Belsay Awakes Play Layout  
- Annotated Changes

BY  
WH/TH

South elevation

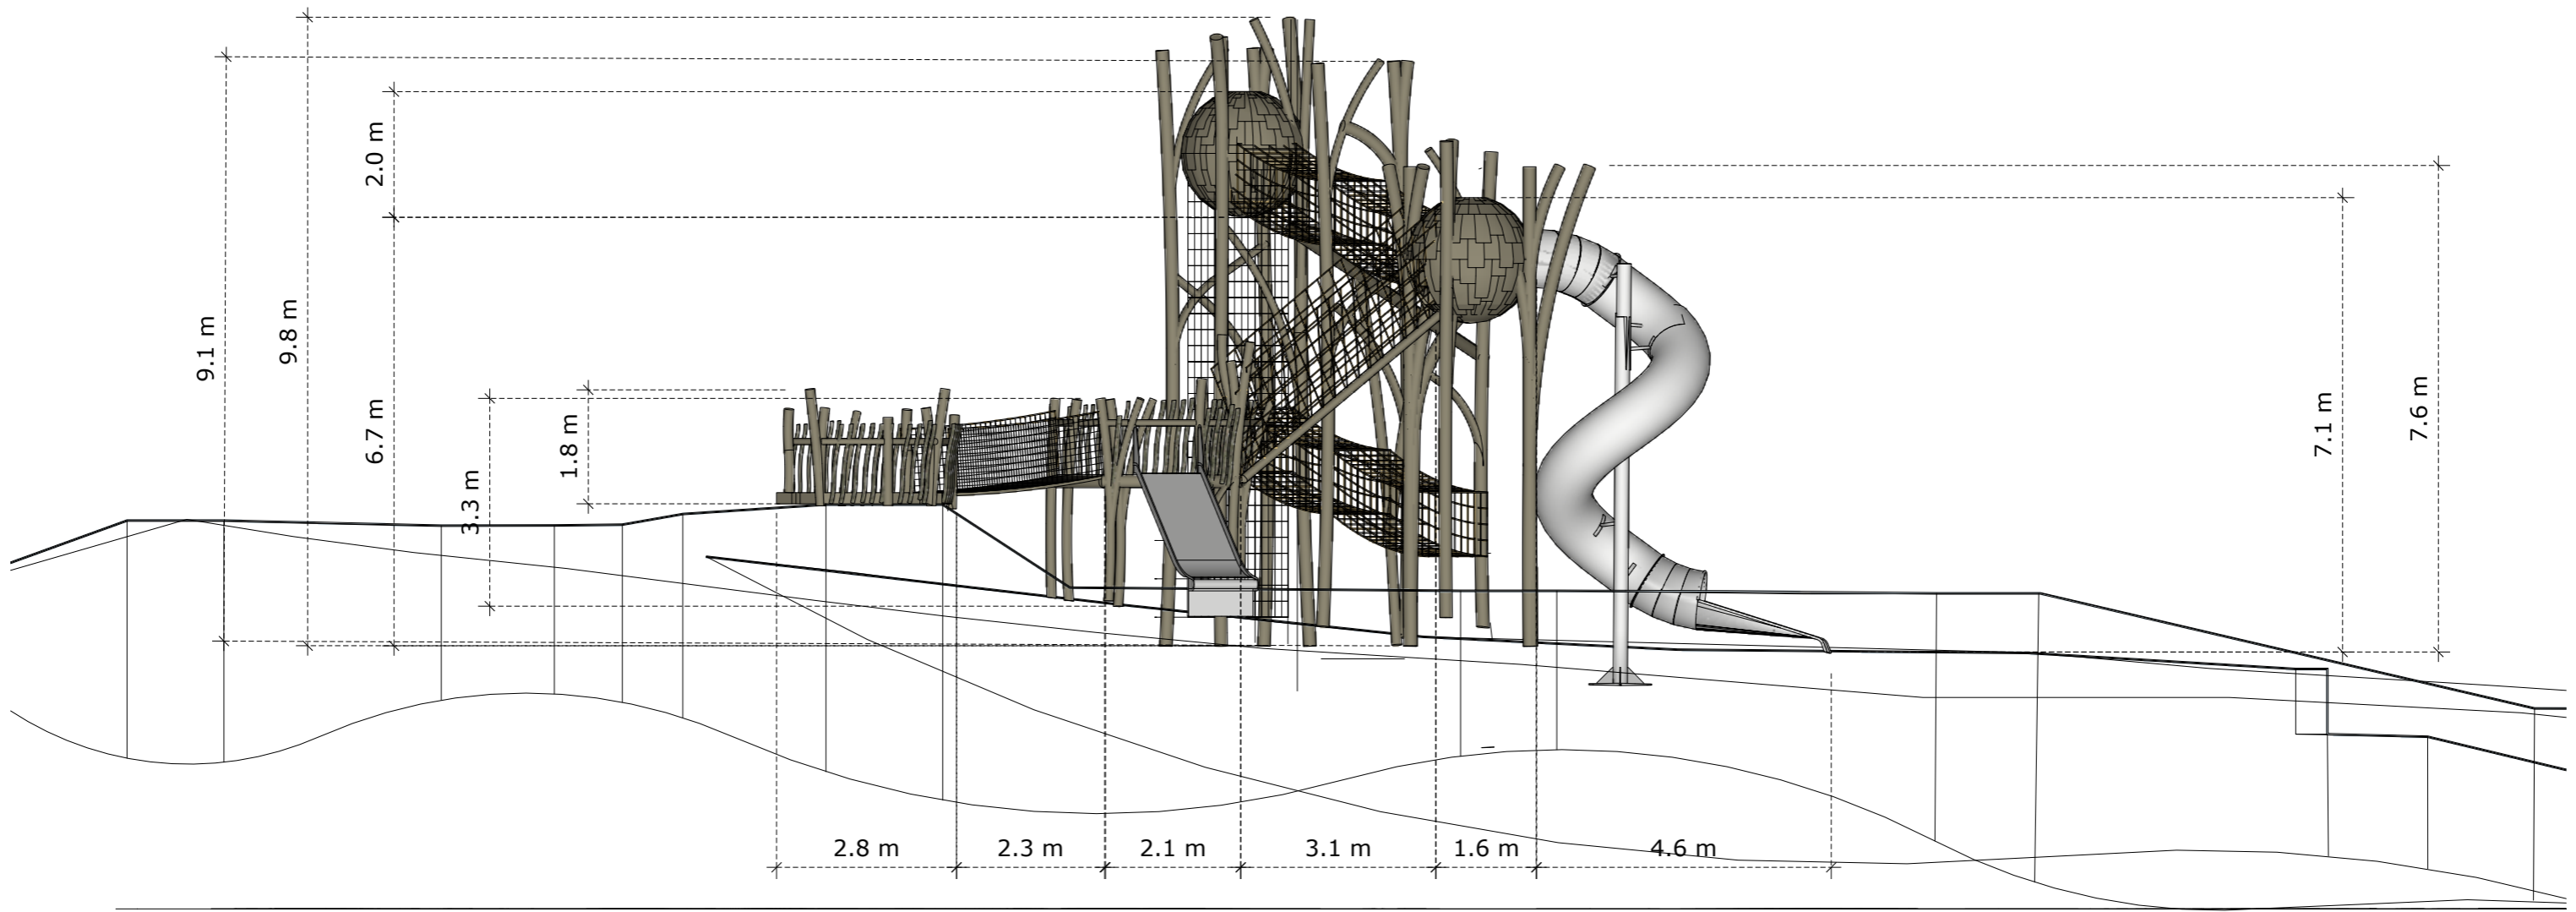
Slight changes in geometry in response to structural engineer's feedback and to further topographic information from Southern Green. Addition of vertical and horizontal climbing nets. Slide partially timber clad.
